From: Andrew Wood <Andrew.Wood@arun.gov.uk>
Sent: 04 November 2019 10:39
To: Peter Terry [REDACTED]
Cc: Planning.Responses <Planning.Responses@arun.gov.uk>
Subject: FW: WA/7/19/RES - Lanes End, West Walberton Lane - Additional information request

WA/7/19/RES - Lanes End, West Walberton Lane - Additional information request

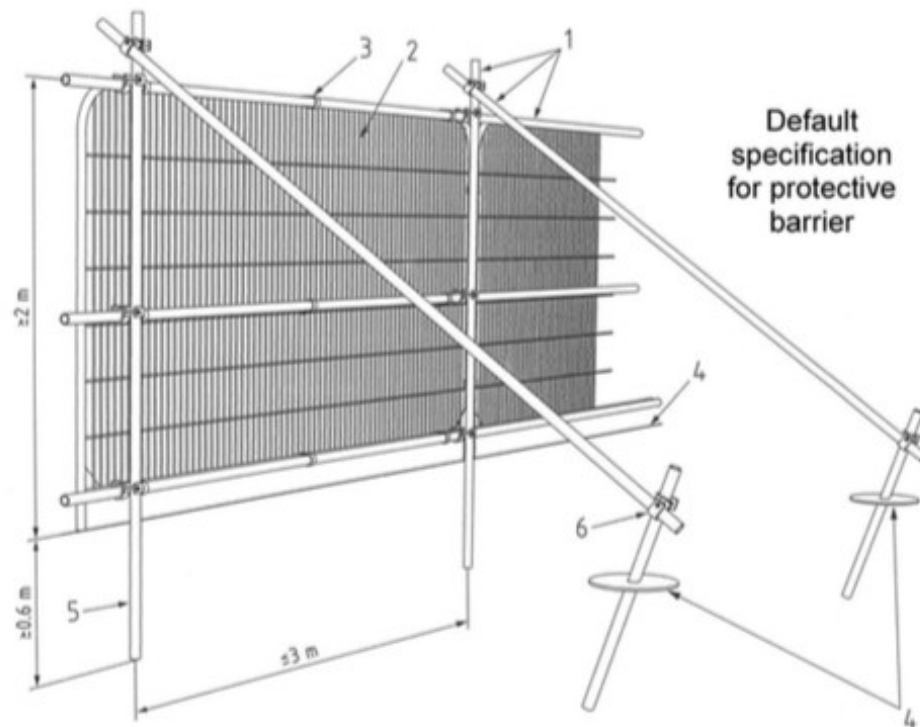
The plan is neither to scale nor based on a topographical map – so it is not possible to determine precisely where the tree protection measures are to be installed. It is only a sketched drawing (an illustration at best) – which is surprising given the typical standard of plans submitted (this was a first for me!) and not at all consistent with the high standard of report it is associated with.
